Your Ref: OWPC20044
Our Ref: WA/72/18/HH 11-07-2018
Please ask for:
Zac Denton

Single storey extension & detached annexe
Falling Foss West Walberton Lane Walberton

Tel: 016973 52033 mail@retreathomes.co.uk www.retreathomes.co.uk		
CLIENT		
Mr R Paterson		
PROJECT		
33 x 22ft 1 bed Retreat		
TITLE		
Floor plan		
SCALE	DATE	
A4 - 1:100	22-08-2018	
DRAWN BY	CHECKED BY	
MAB	A Rooke	
DRAWING STATUS		
Proposed		
DRAWING No	REV	
RP-08-08-2018-V0	3

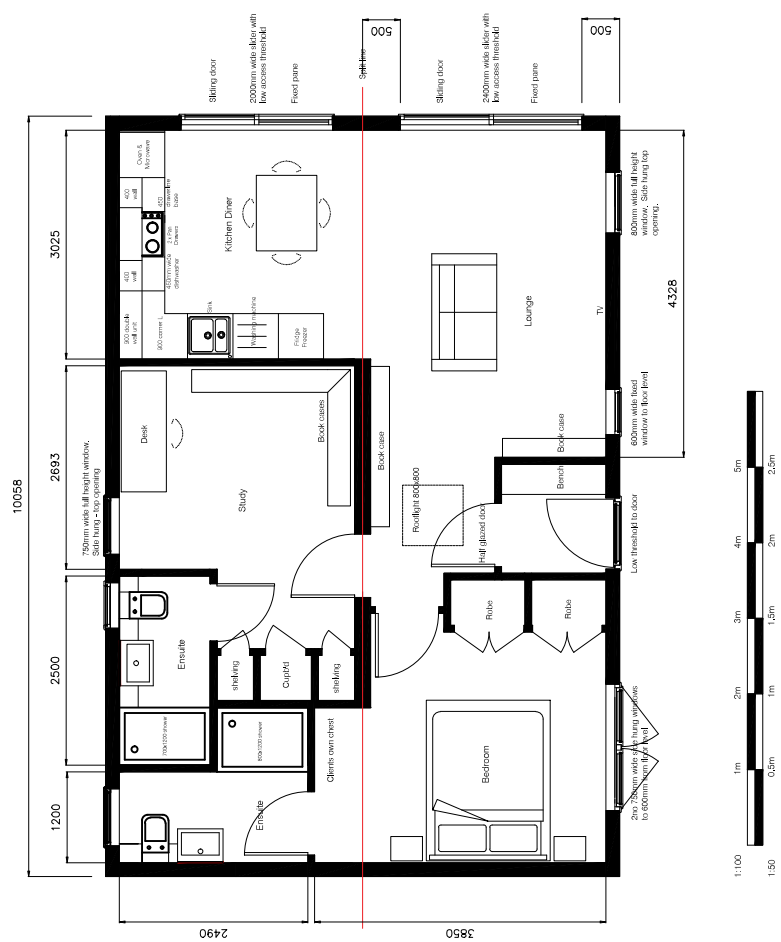
I also note that the latest docs refer to a "prefab" which appears to be more than a "Granny Annex". I find it difficult to visualise the extension blending in with neighbouring residencies in West Walberton Lane. Having cut down mature trees fronting West Walberton Lane the new building will also be exposed to view from West Walberton Lane and properties opposite. I consider that the trees on the common boundary with the property west of the prefab remain and that suitable bushes and small trees be placed around the prefab to act as a screen
